Barangaroo - Headland Park - Main Works MP10_0048 – Major Project Submission

Submission to the Department of Planning 24 December 2010

City of Sydney

**MAIN WORKS APPLICATION
CARPARK & FUTURE CULTURAL FACILITY
PLAN RL 25.0**

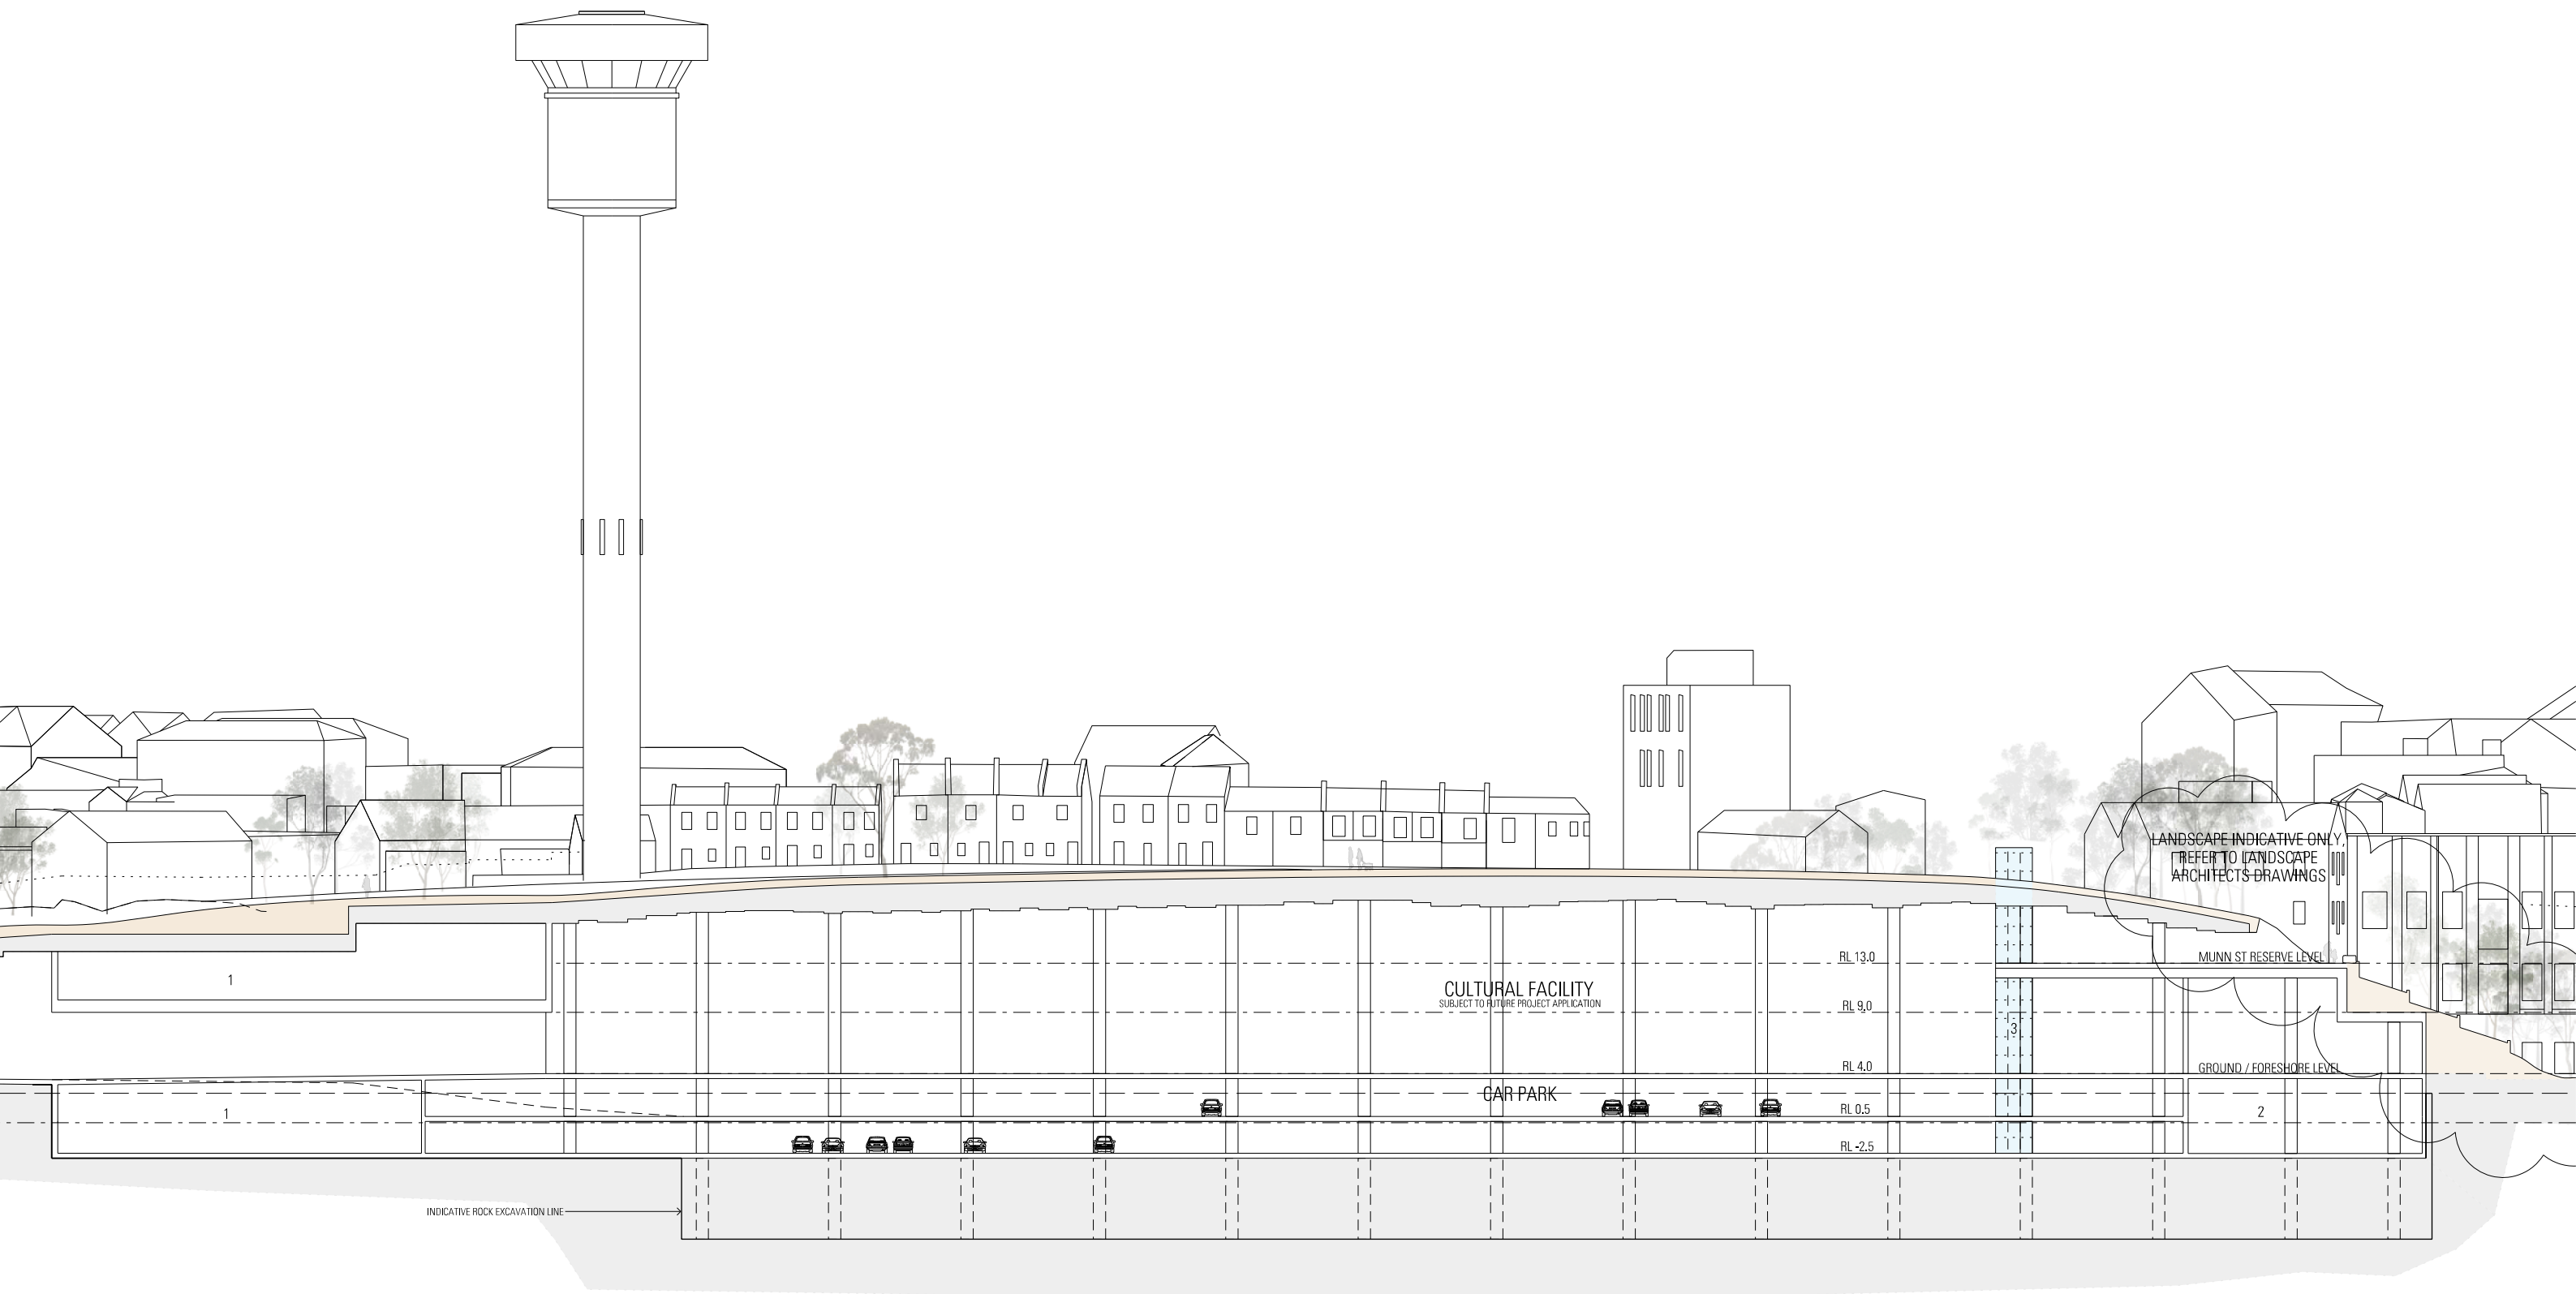
As proposed, the space under the headland is designed as an internalised shell with only two entry points at the southern end of the park (at RL4 and RL13). Similarly, the car park under the headland is provided with a main pedestrian access point via the cultural facility at the southern end of the park, with a secondary access path along the driveway ramp in the north.

Cultural facility: The cultural facility shell is provided with two pedestrian access points at its southern end, providing access to the same location from different levels. Pedestrian access to this facility from Walsh Bay is important to connect it with the existing cultural precinct, and should be provided through design amendment.

Car park: The main pedestrian access to the car park is provided via lifts through the cultural facility at the southern end. People using the car park to access the Headland Park or the facility itself would be well served by this access point. Due to its proximity to the Walsh Bay cultural precinct, adequate pedestrian access also needs to be provided to the car park from the northeast. In the current scheme, a narrow pedestrian path is provided alongside the vehicular entry ramps into the car park. The location and design of this accessway should be improved to ensure adequate quality, safety and accessibility are achieved without creating pedestrian/vehicular conflict.

The proposal includes several circular lightwells into the cultural facility shell. The number and location of the lightwells is unclear as they are inconsistently shown in the documentation. Four lightwells are shown on some plans and three on other plans, with their location varying also. No sections or images are provided showing how the lightwells are treated at the park level – whether they are raised structures or sunken glass as indicated for the cutting along Merriman Street. The lightwells are located at the top of the headland in the most level, useable open space in the park. The size, location and treatment of any lightwells will significantly impact on the appearance and useability of the park, and additional information and documentation is to be provided before their impacts can be assessed.

- The design should be amended to include carefully located and adequate park amenities (additional toilets, kiosk, café, shelter etc), integrated within the headland "shell" structure but accessible from multiple locations around the park.
